## Re: 31 Fore Street- finalizing the plan set/building permit process

**Subject:** 31 Fore Street- finalizing the plan set/building permit process

I understand that a building permit application has been received for the demolition of the existing building and the construction of the new 4-unit building

**BICYCLE HITCH DETAIL**  
NOT TO SCALE

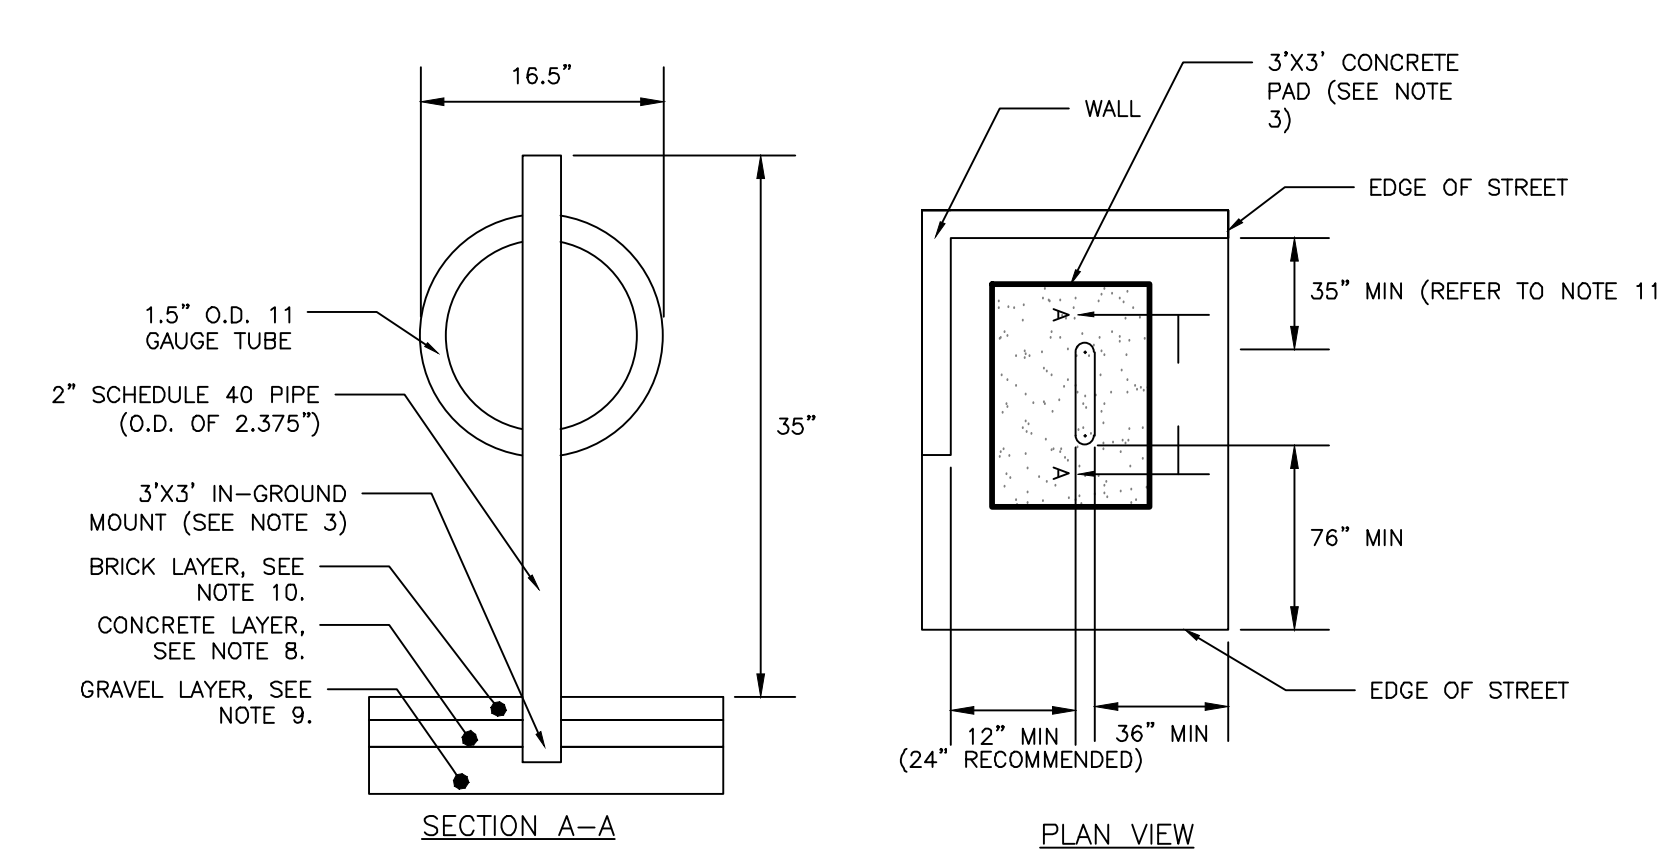
*b. Ensure that the bicycle parking hitches in the ROW are designed to meet the Technical Standards; and*

The bicycle hitch as detailed on C-41 Site Details 2 is designed to comply with the Technical Standards outlined in Section 1, Figure I-33c.

DRAWING NO. C-30

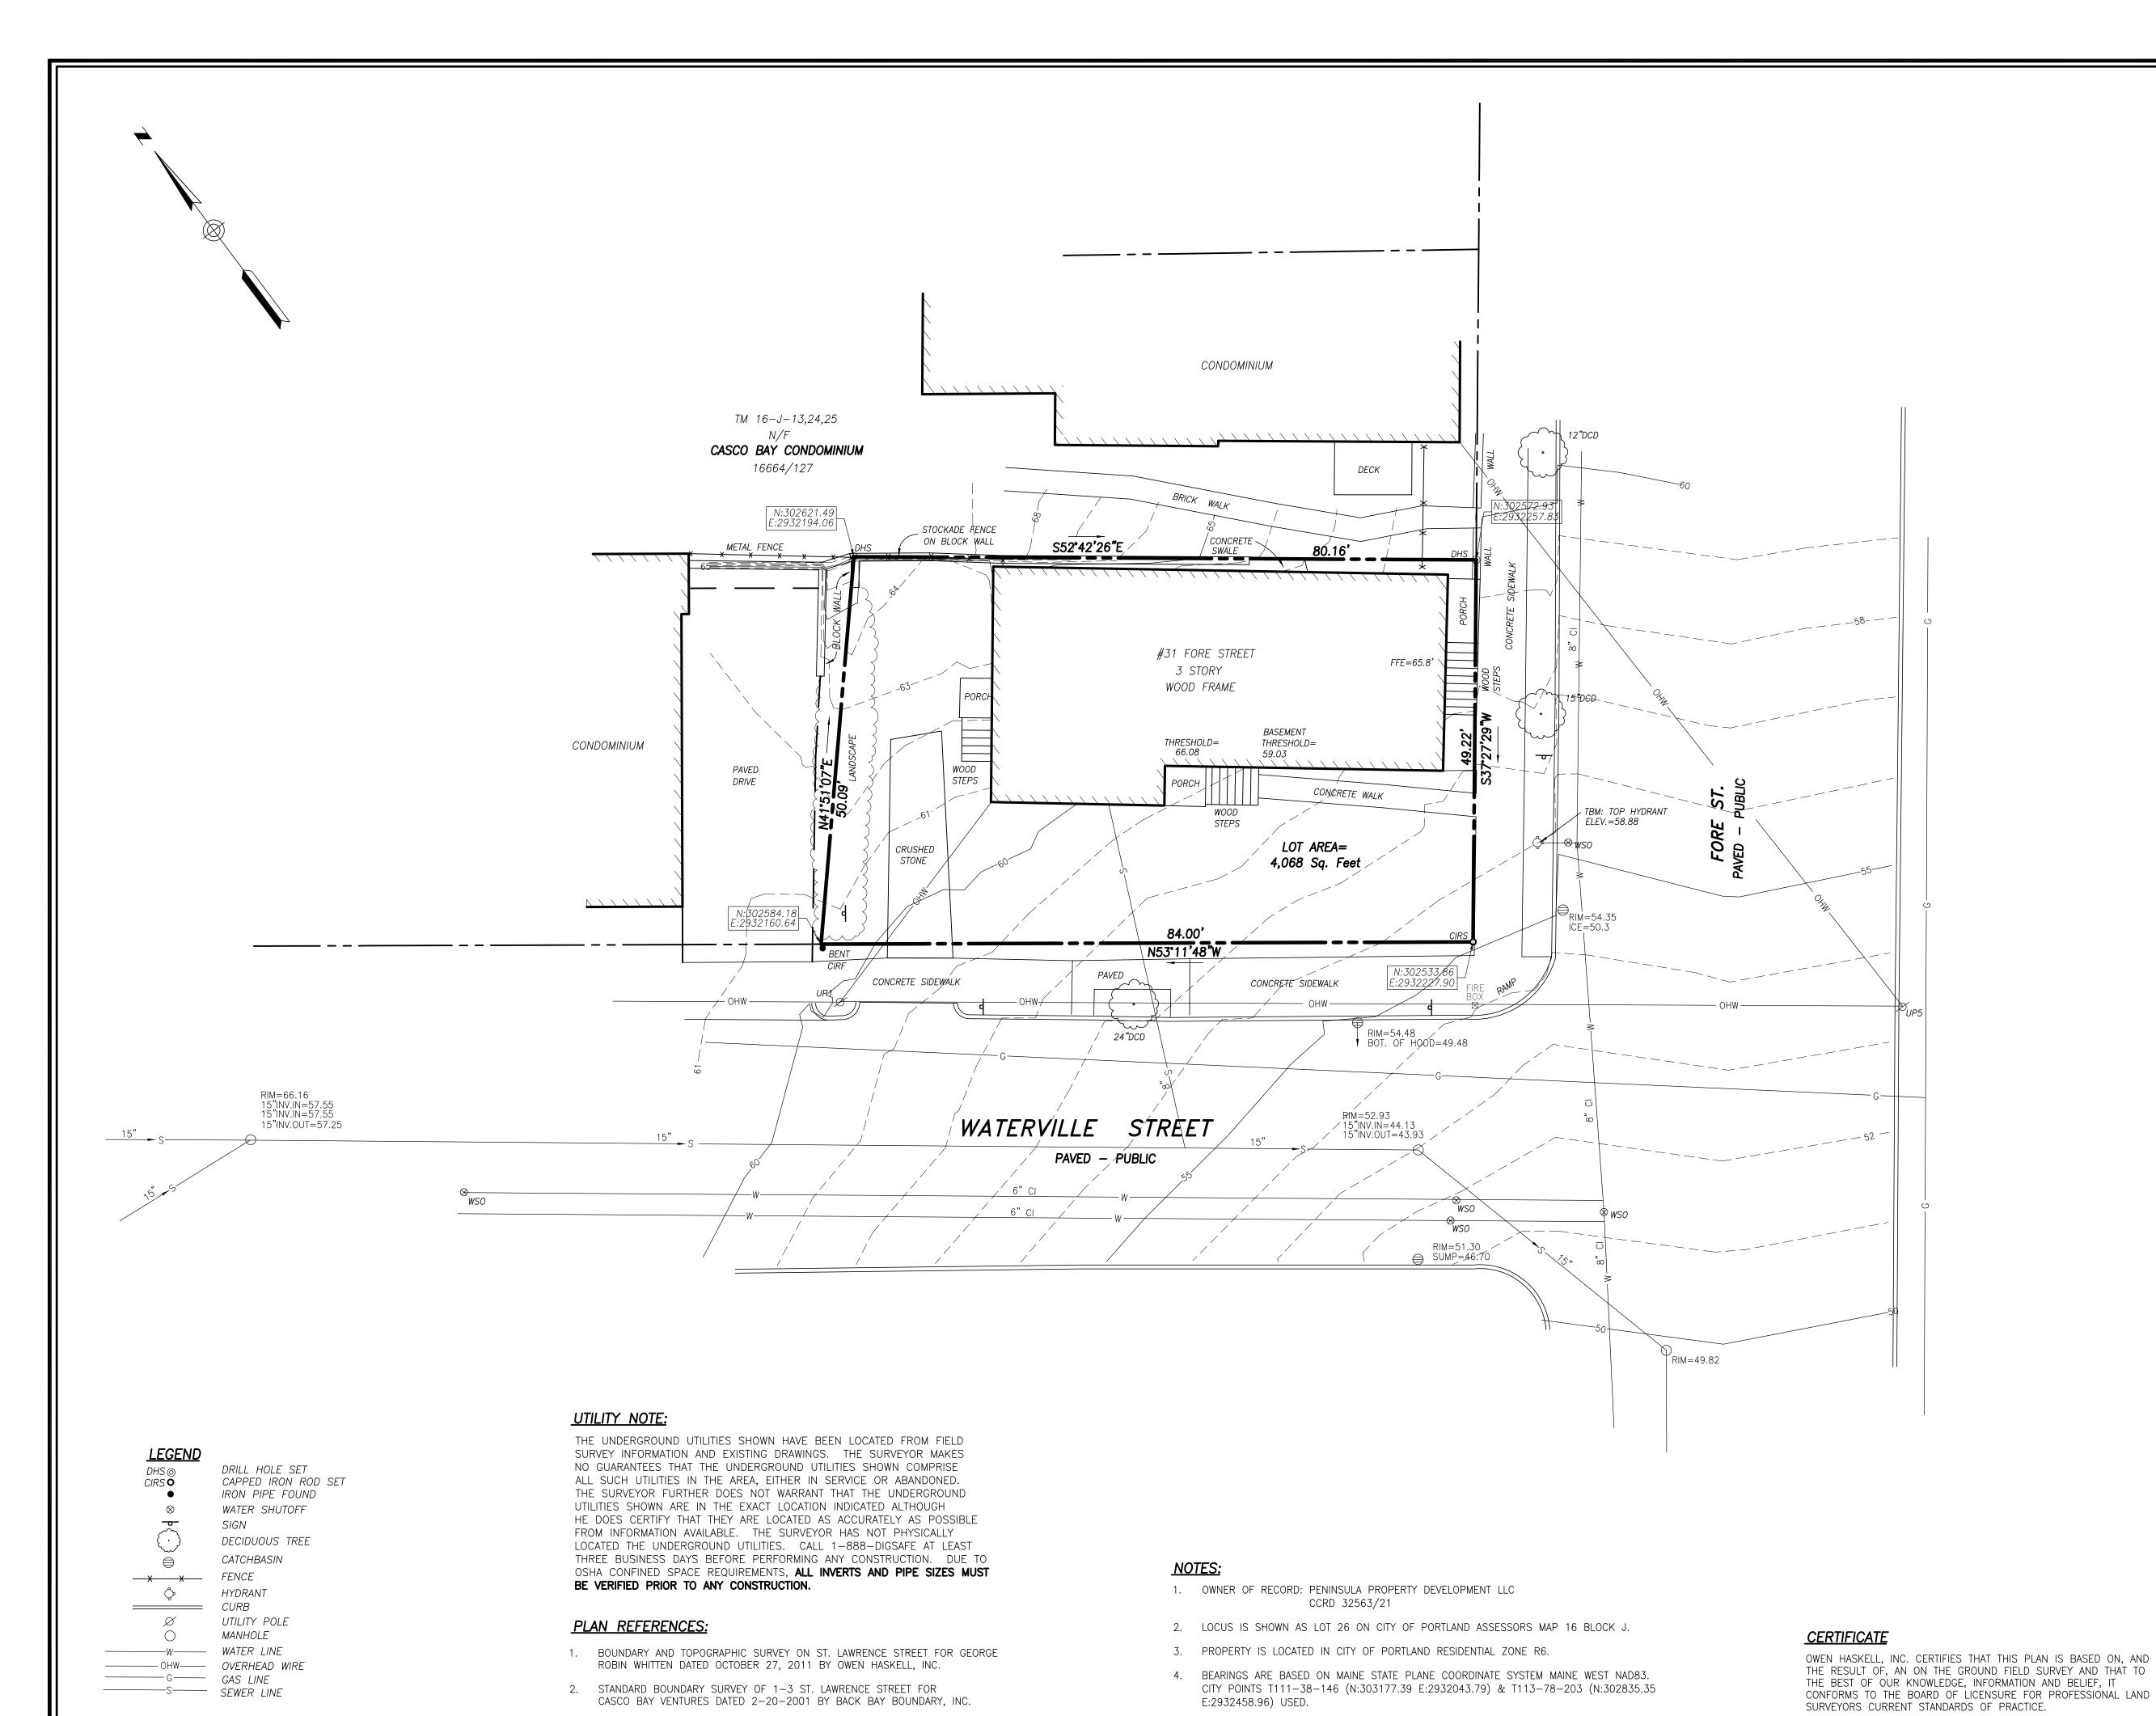
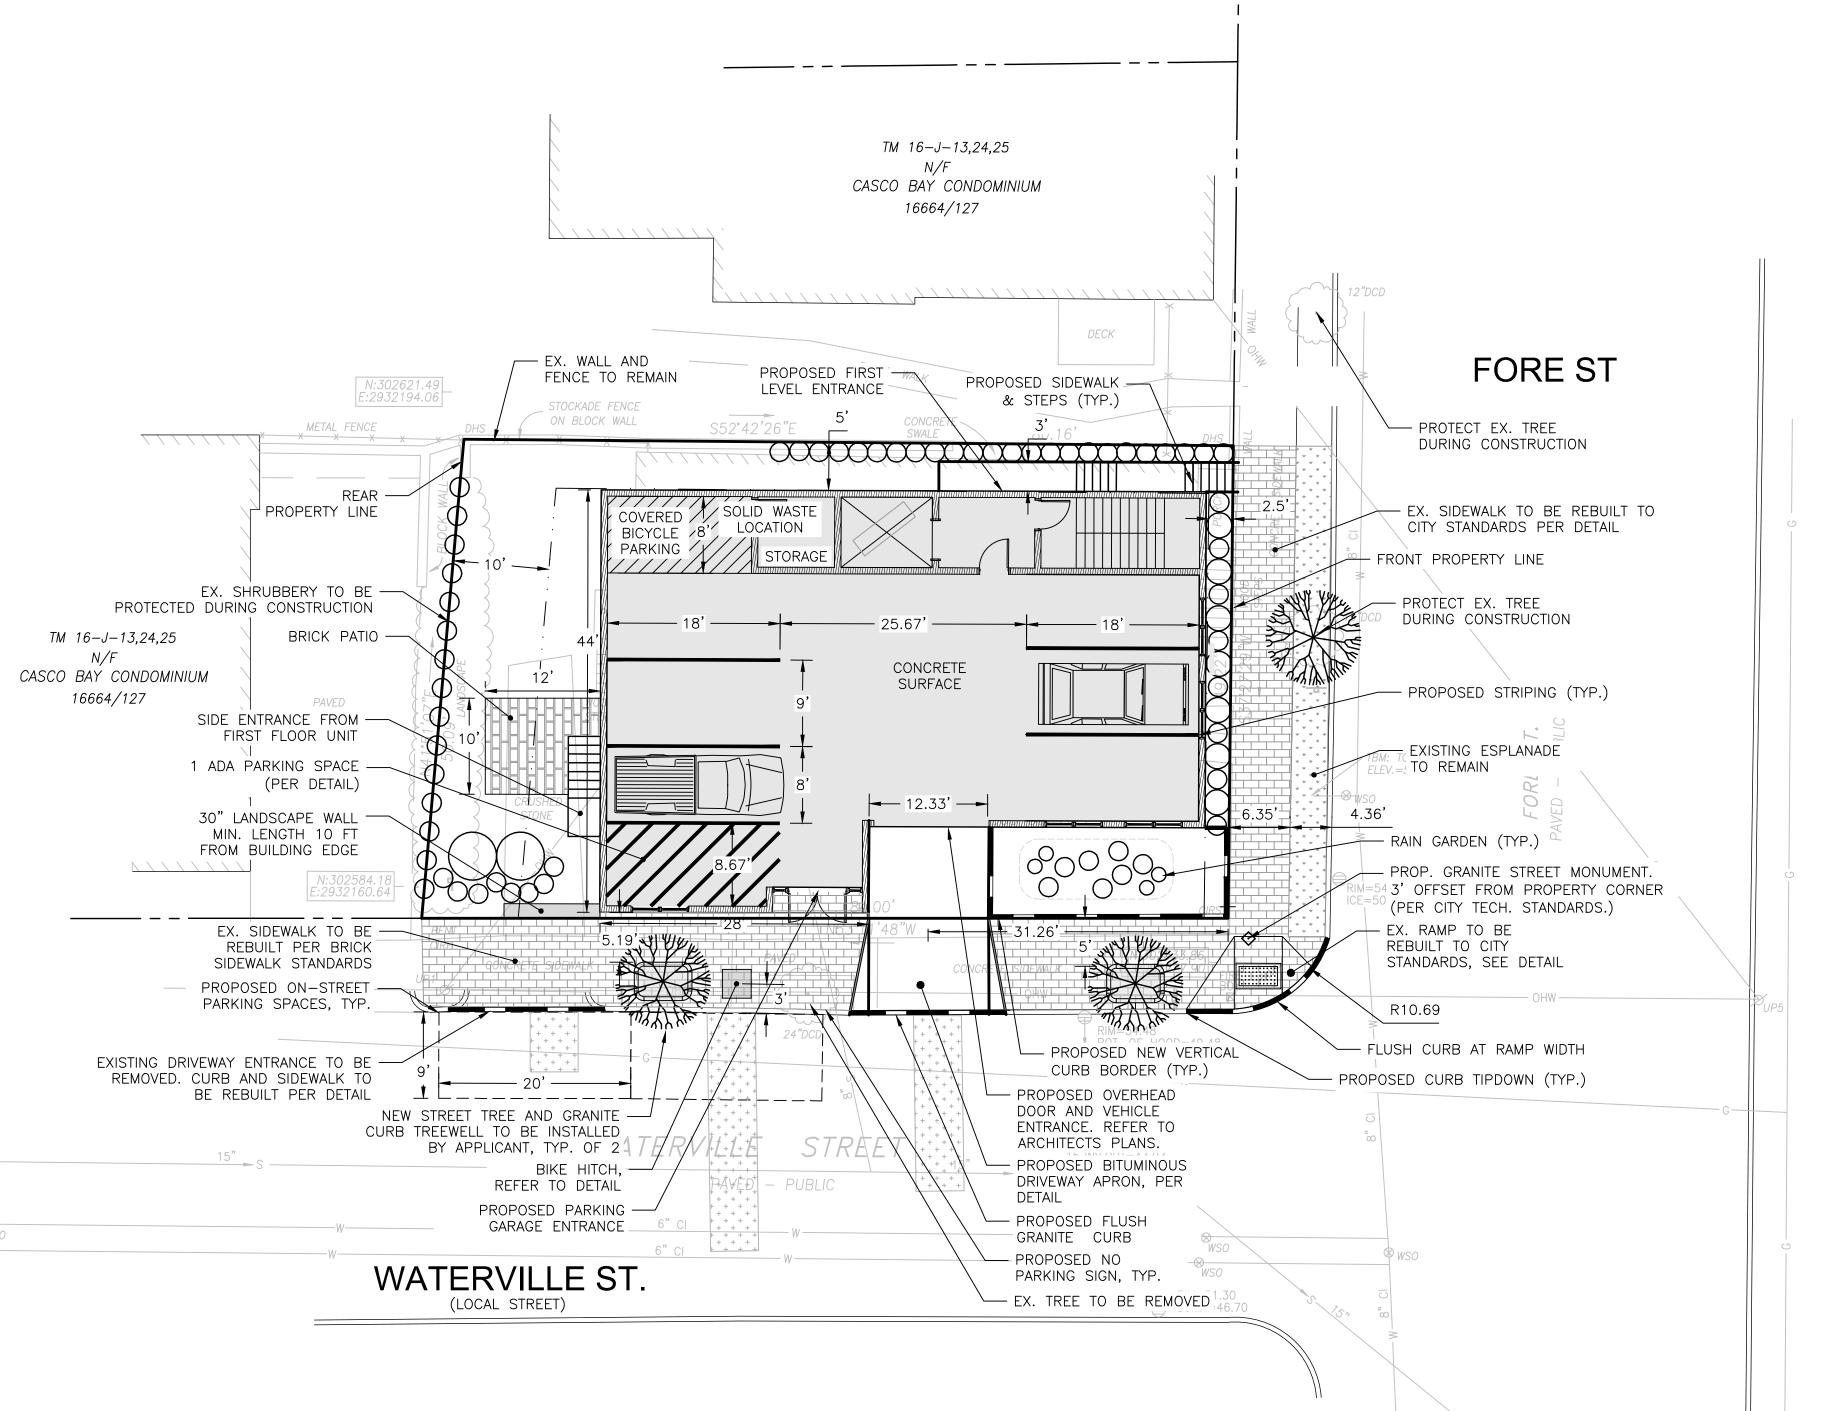
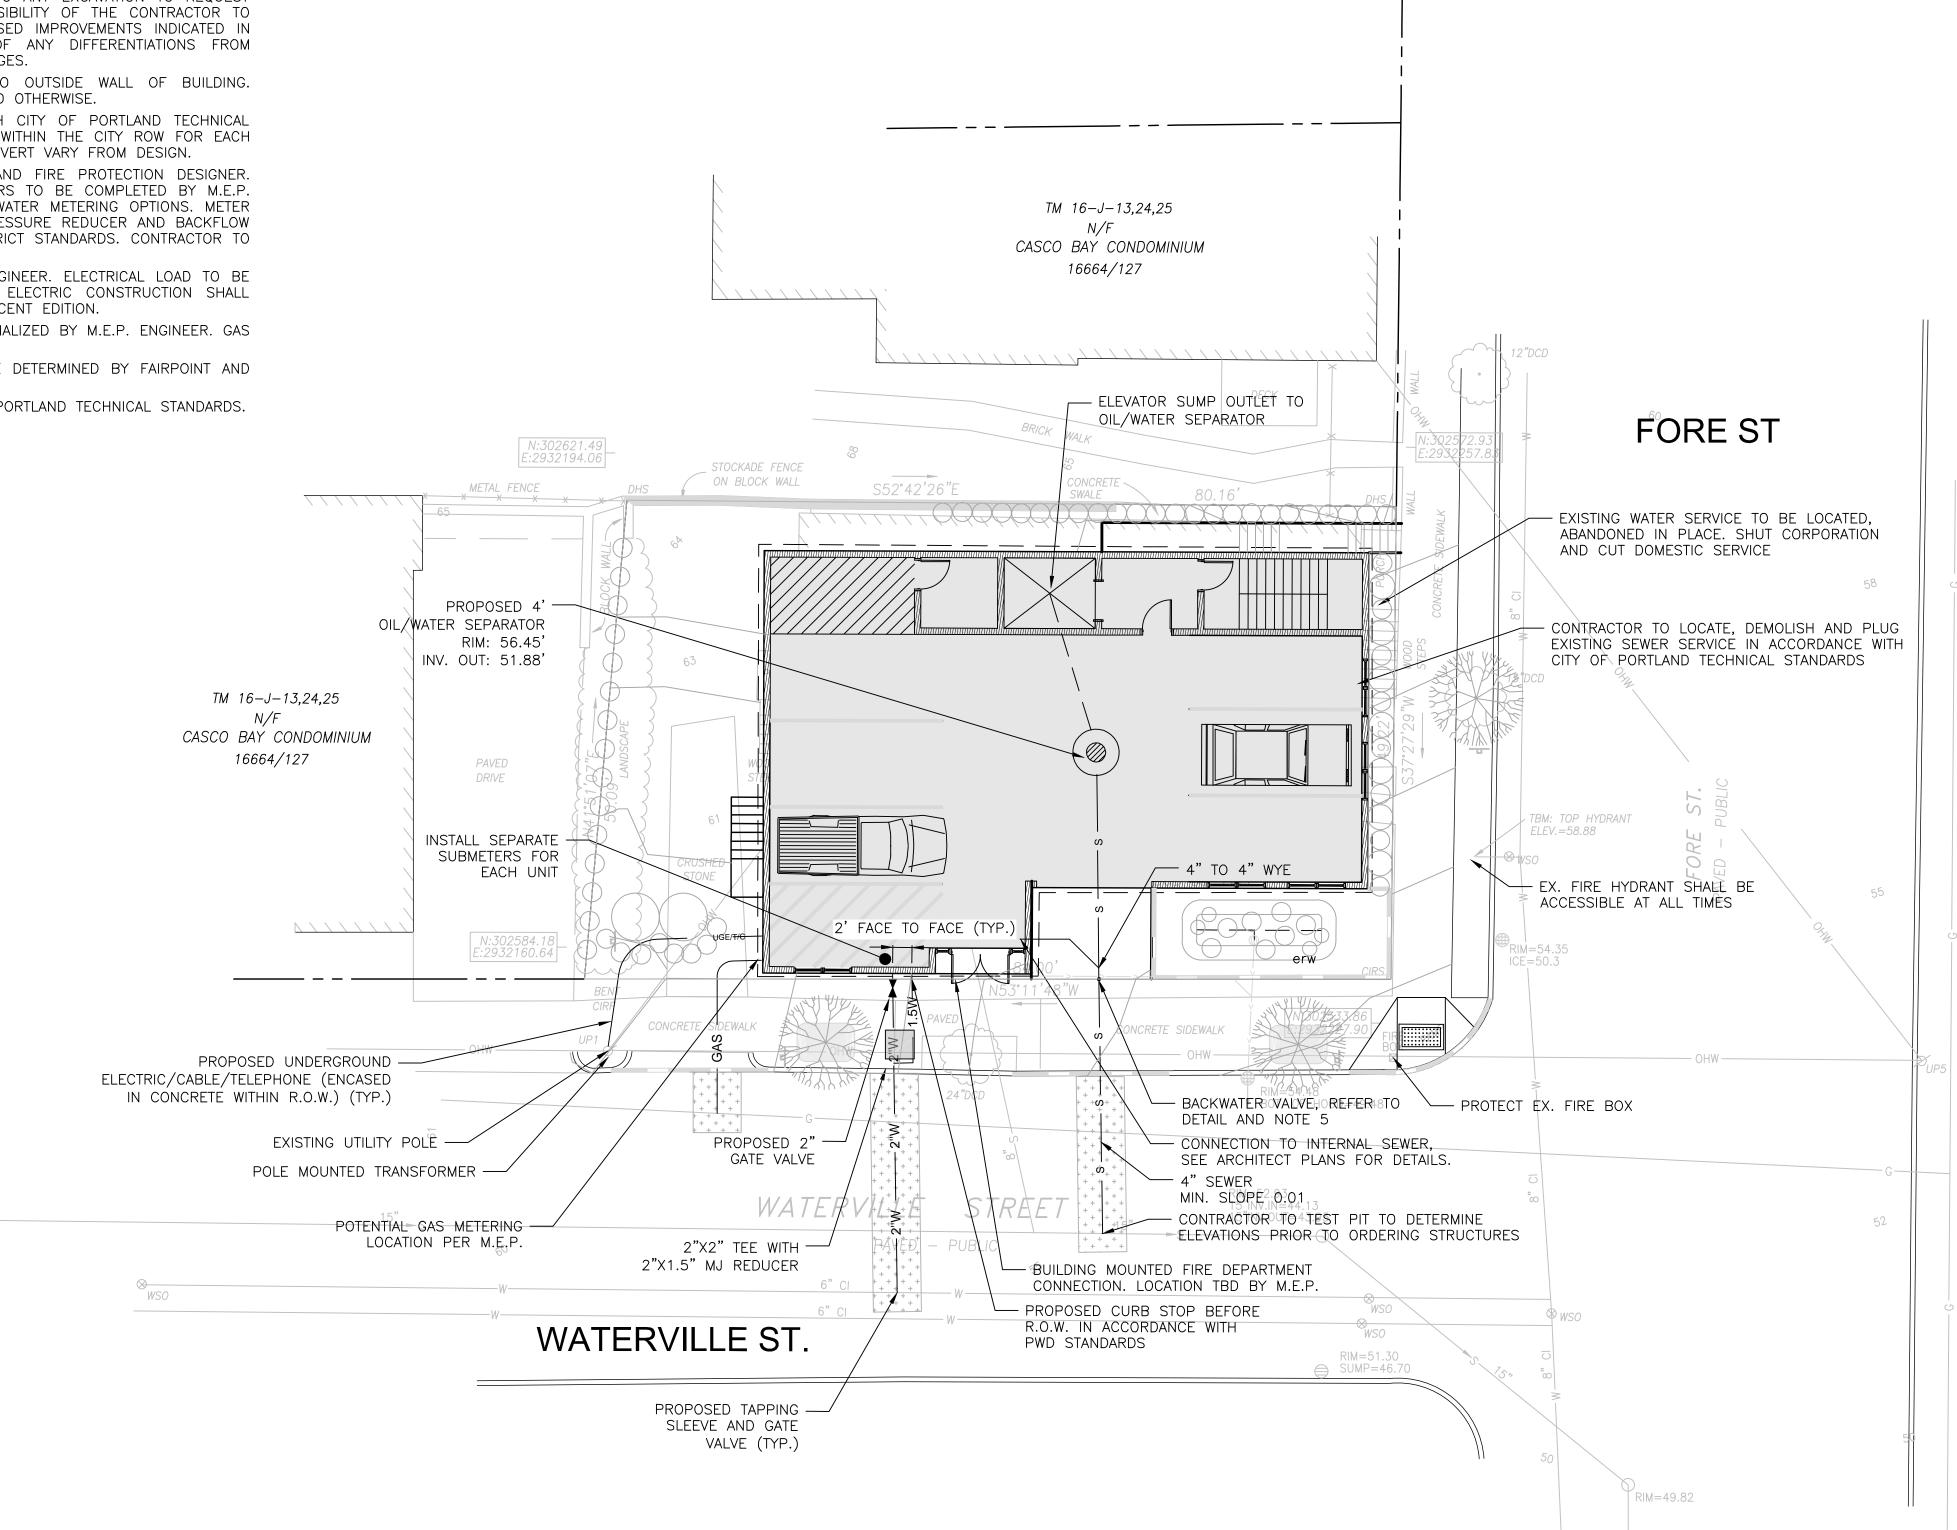
Regarding the Site Plan vii, please also show on the plan that the grade leading up to the side entrance and within the garage meets ADA requirements - since these areas have

been modified to provide ADA access to the parking space.

**As outlined in C-30 Grading and Drainage Plan, additional spot grades were added to the side entrance and internal garage further clarifying that the slope does not exceed 2% per ADA requirement.**
